Peppertree Quarry Modification 4

RESPONSE TO SUBMISSIONS

PEPPERTREE QUARRY MODIFICATION 4

RESPONSE TO SUBMISSIONS REPORT

Figure 9: Catchment locations on the site of the proposed emplacement area

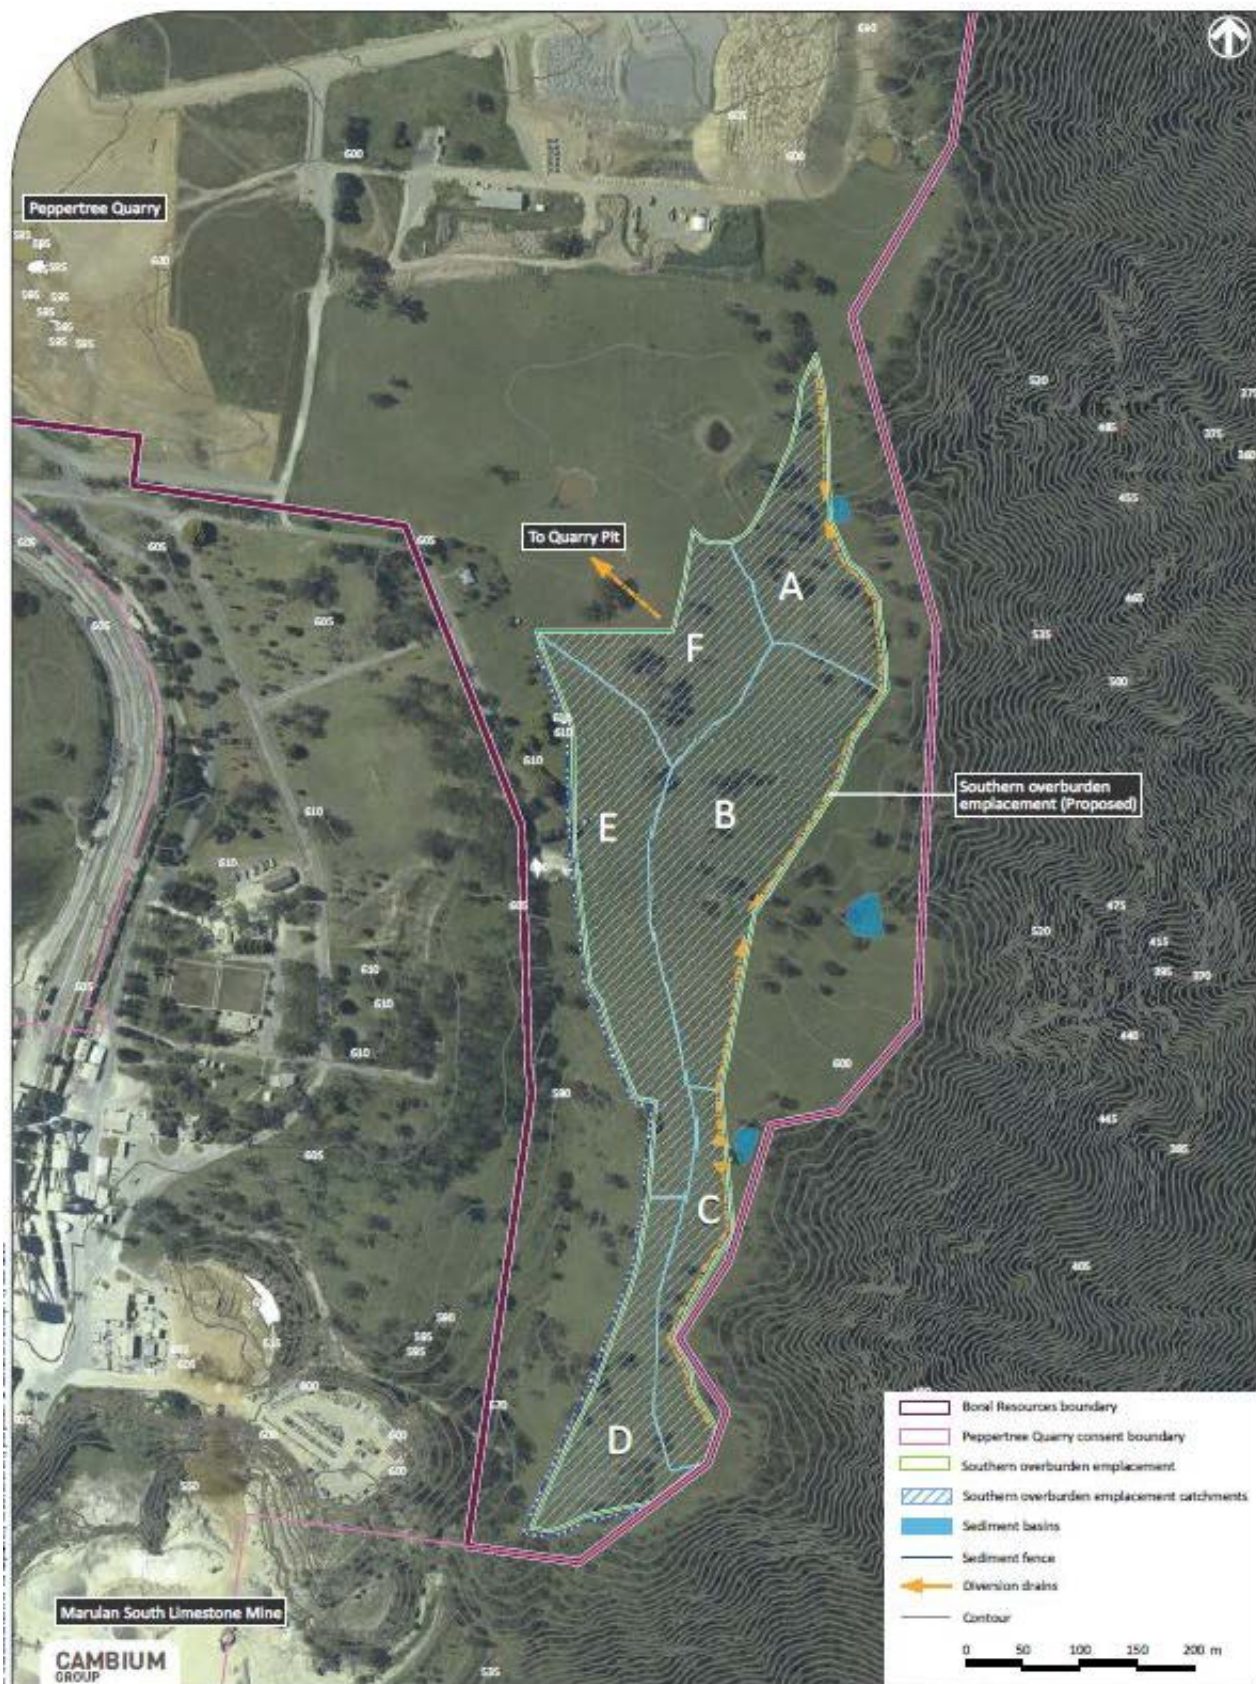
Given the layout and topography of the area, the EPA is concerned that runoff from the south end of proposed new southern overburden emplacement area (Catchment D) may not flow into the North Pit of the Limestone Mine as stated in the SWA. Drainage plans for the proposed southern overburden emplacement are provided in Figure 4.1 of the SWA and it is noted that a drainage line runs along the south east of the proposed emplacement, but does not continue further along the far southern end of the emplacement area (Catchment D).

Given the sensitivity of the environment to the south of the proposed modification, including Morton National Park, the Shoalhaven River and the Bungonia Gorge, the EPA is concerned that sediment fencing alone may not be adequate to protect the environment from the sediment runoff in the event of a significant rainfall event.

The EPA suggests that instead of (or in addition to) the proposed sediment fences along the southern end of the proposed emplacement area, the proposed catch drain along the south-east of the stockpile should be extended along the southern tip of Catchment D. This proposed catch drain could either flow to the west to enter the drainage line which flows into the North Pit of the Limestone Mine, or north-east and north to the proposed sediment basin on the eastern edge of

Boral have considered the EPA's suggestions on the management of sediment and stormwater runoff from the proposed Southern Overburden Emplacement and have amended the proposed surface water management concept as follows:

- The diversion drain for Catchment C has been extended further south-west so that it ends at the catchment divide (with Catchment D);
- The proposed sediment fence along the southern boundary of Catchment D has been replaced with a diversion drain;
- A 'level spreader' has been included at the south-western corner of Catchment D at the diversion drain discharge point. The level spreader will act as an energy dissipater and scour protector, dispersing storm water flows from the diversion drain down the slope to the drainage line that discharges into the north pit of the Marulan South Limestone Mine.

These amendments have been captured in a revised surface water management concept plan, included as Appendix B.
